Condition 11- Surface Water Drainage Design

Application No: **CM/11/21/DOC**

Registered: 5th March 2021
Site Address: Scyld Horsemere Green Lane Climping BN17 5QZ
Description of Works: Approval of details reserved by condition imposed under CM/21/19/PL relating to conditions 11-surface water drainage scheme, 12-discharge of flows to water courses or for the culverting, diversion, infilling or obstruction of any water course on or adjacent to site & 13-maintenance and management of surface water drainage system.

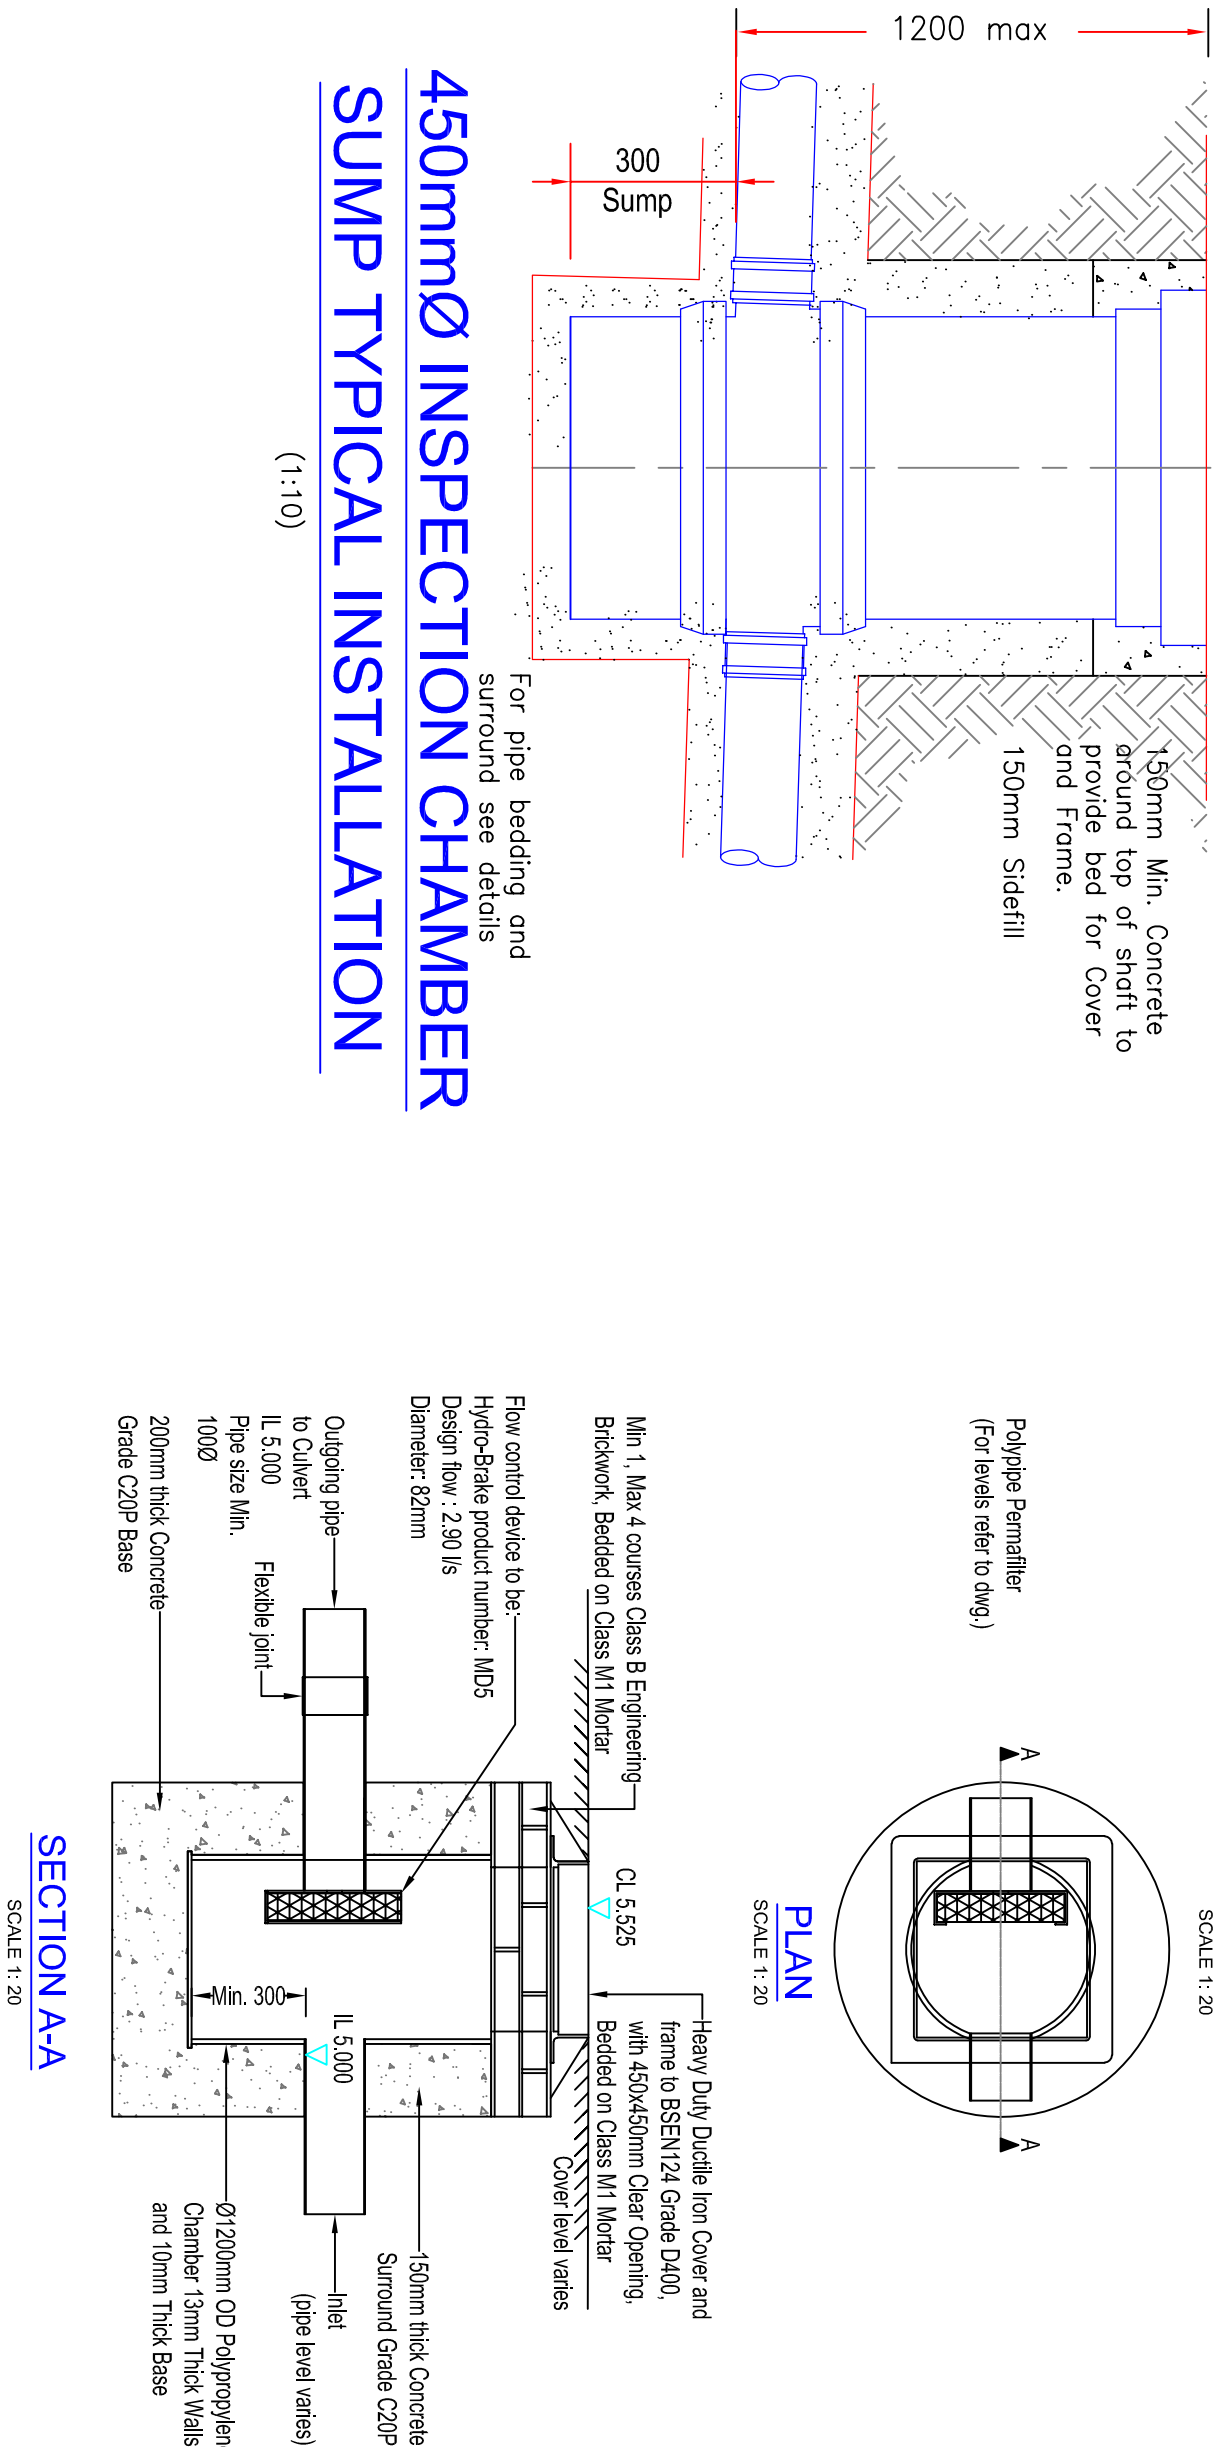
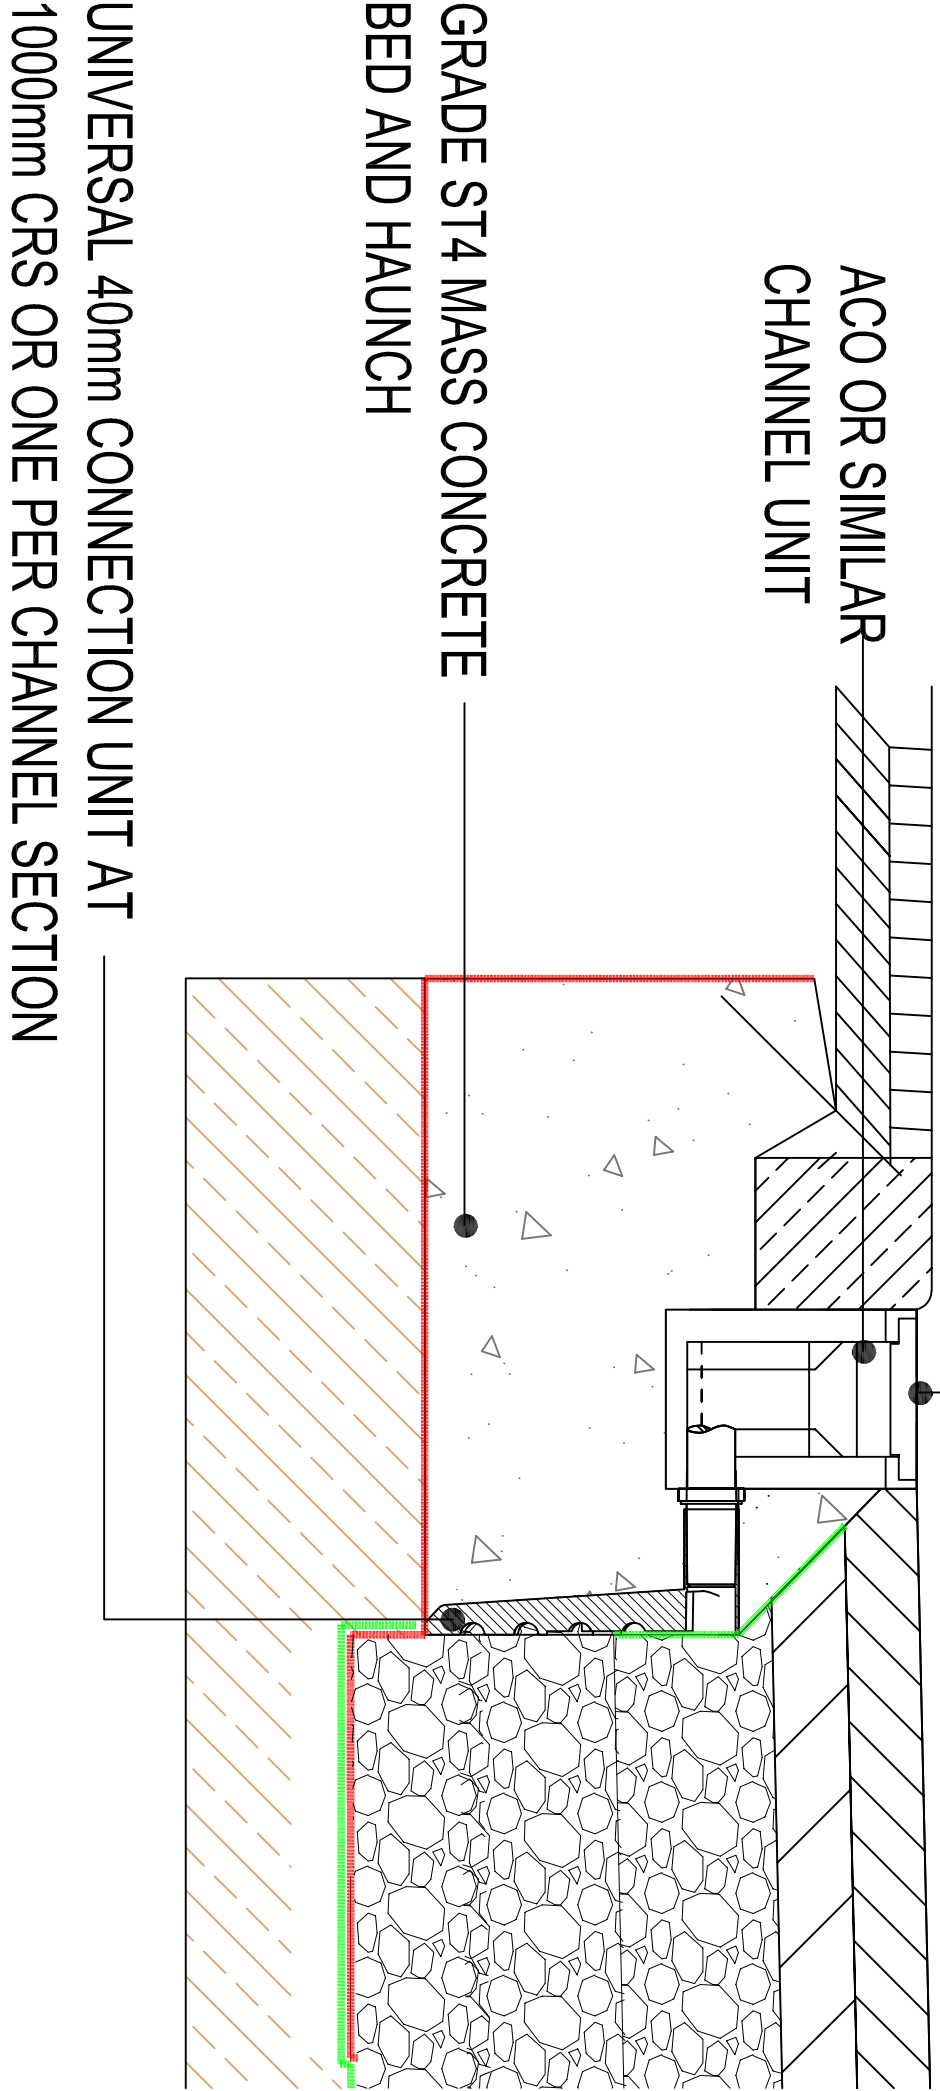
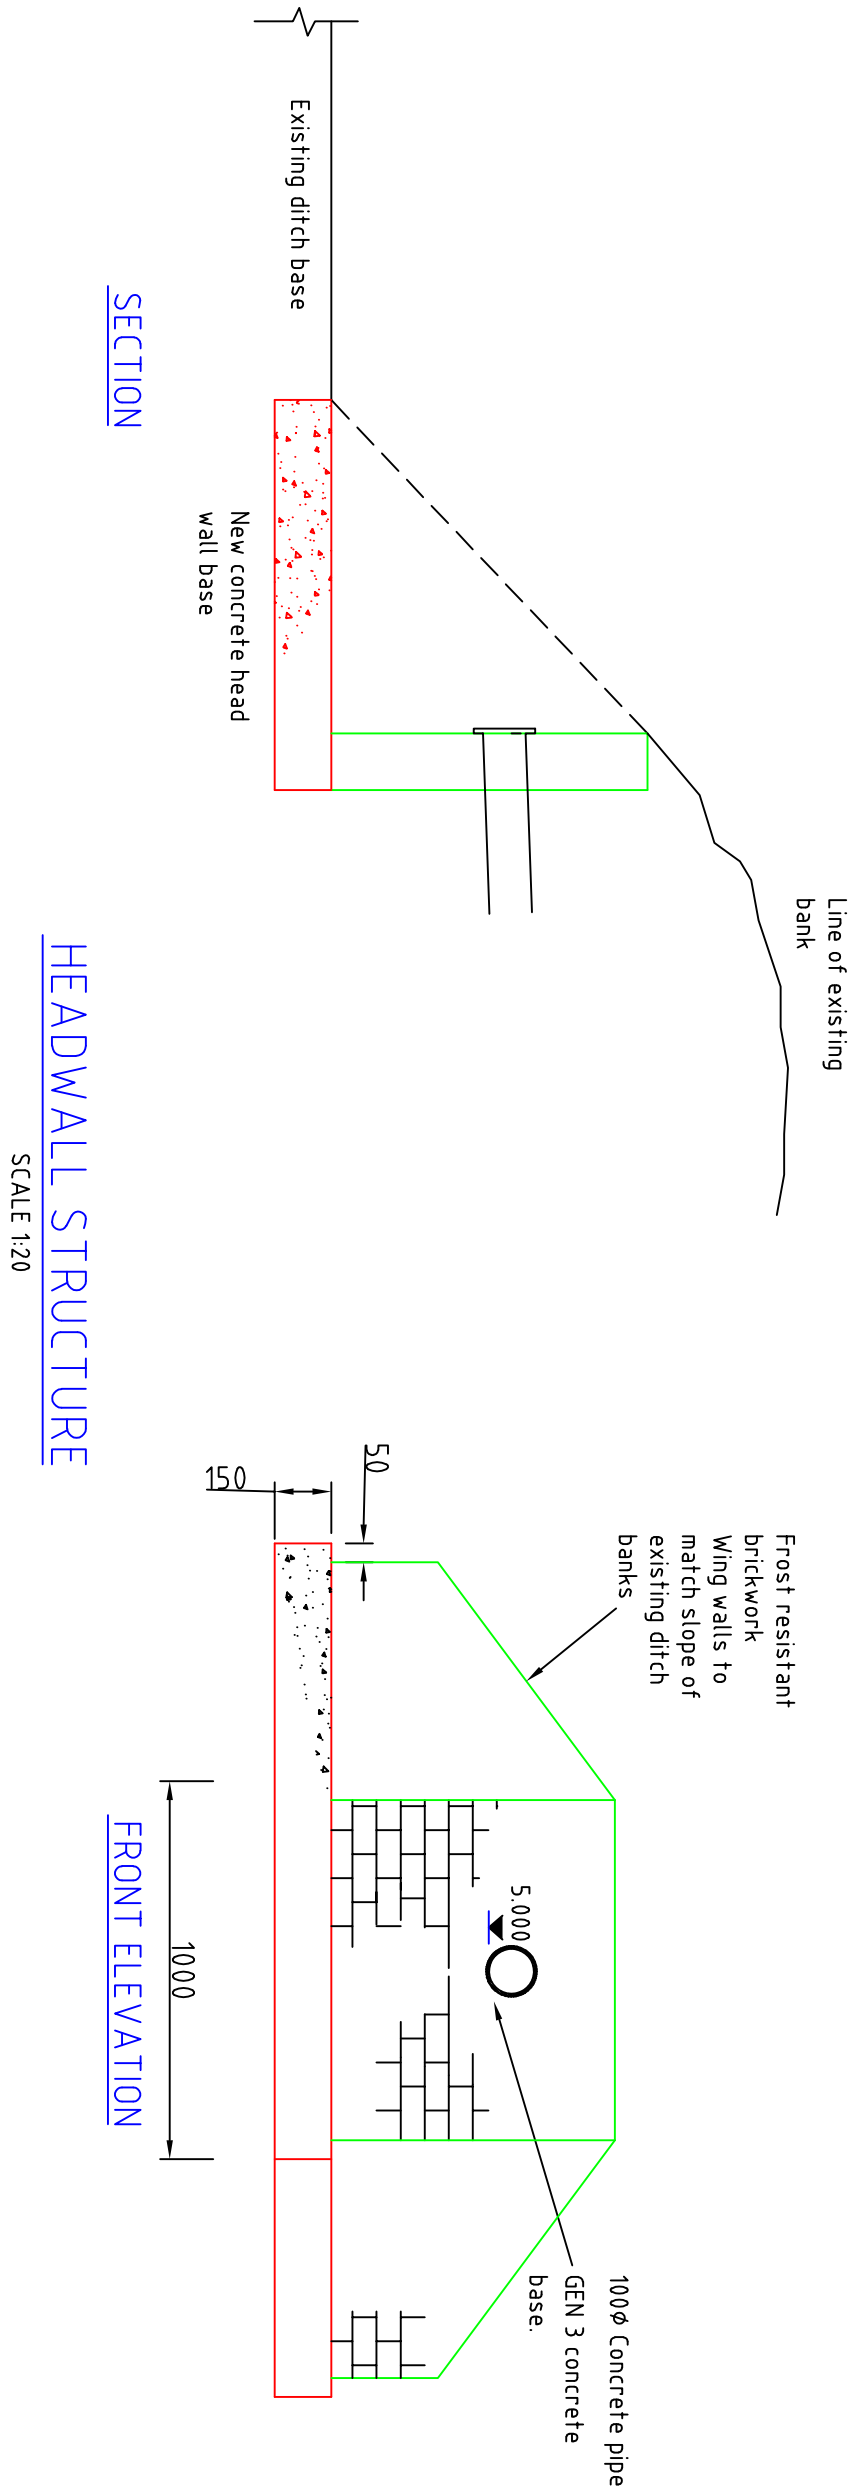
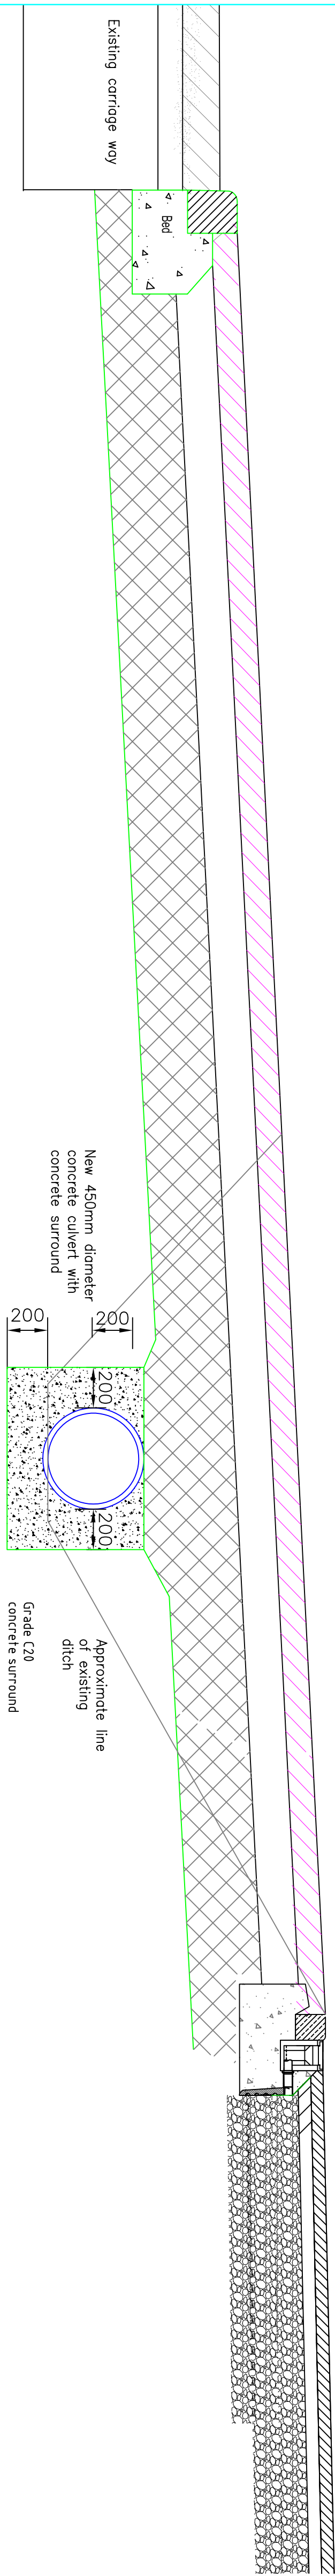
3. The long section on the drainage details sheet 1 refers to a hydrobrake with a restriction of 2.0l/s, which conflicts with the calculations, other details and layout (although addressing point 1 will affect these). This is now correct after the revised calculations, other details have been updated accordingly. See comment below.

5. Please make the permeable paving construction details clearer. I.e. please provide one which clearly details the driveway construction, and one which details the road construction. Both must clearly state minimum required sub-base depth. I have updated the sections to show one for the access road and another for the driveways. *Drainage details 1 of 2 not provided with this package of information, please provided.*
